**\*PRE-HEARING STAFF ANALYSIS\***

**Rezoning Petition No. 2008-037**

**Petitioner:** Ronald McDonald House of Charlotte

**Request:** R-12MF, multifamily residential up to 12 dwelling units per acre to O-2(CD)

REZONING PLAN

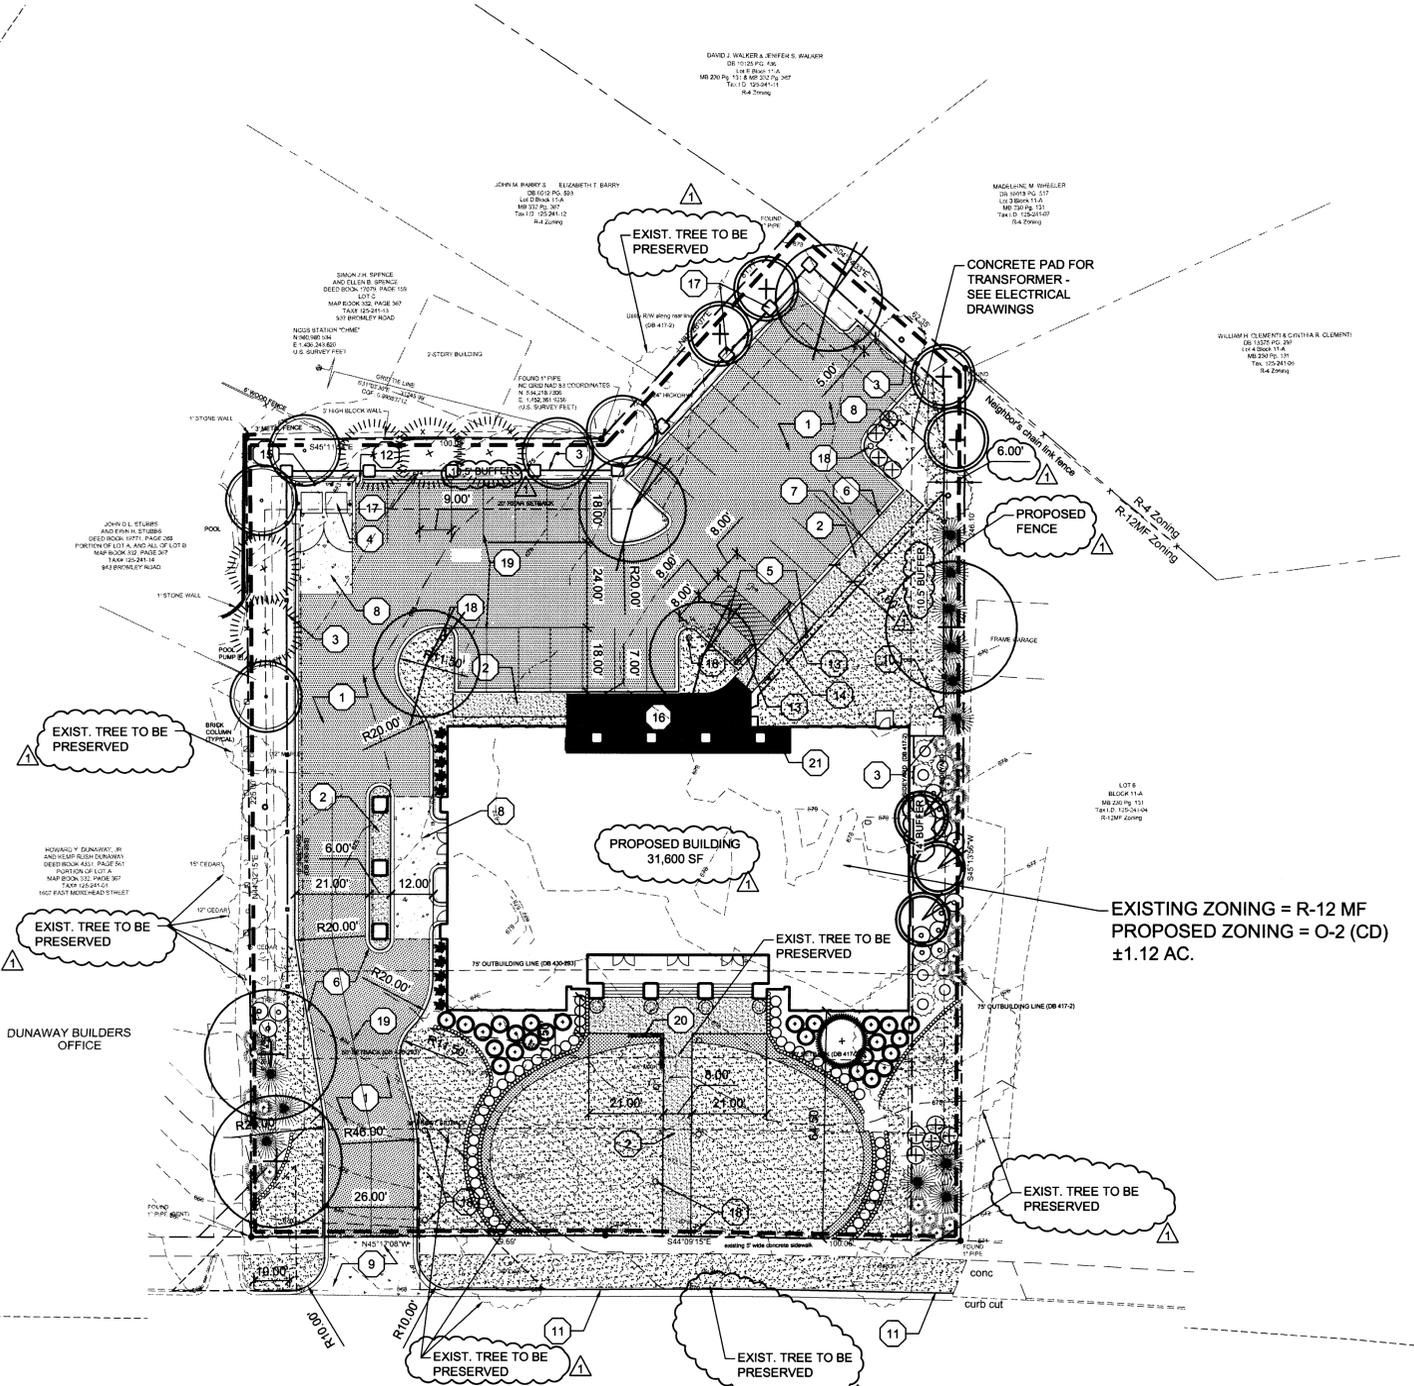
**Storm Water.** Storm Water Services (SWS) has reviewed the petition and notes the site drains to a stream listed as impaired by the NC Division of Water Quality. SWS has provided additional comments regarding storm water quantity control, storm water quality treatment, and volume and peak control.

1. Petitioner shall address storm water comments.
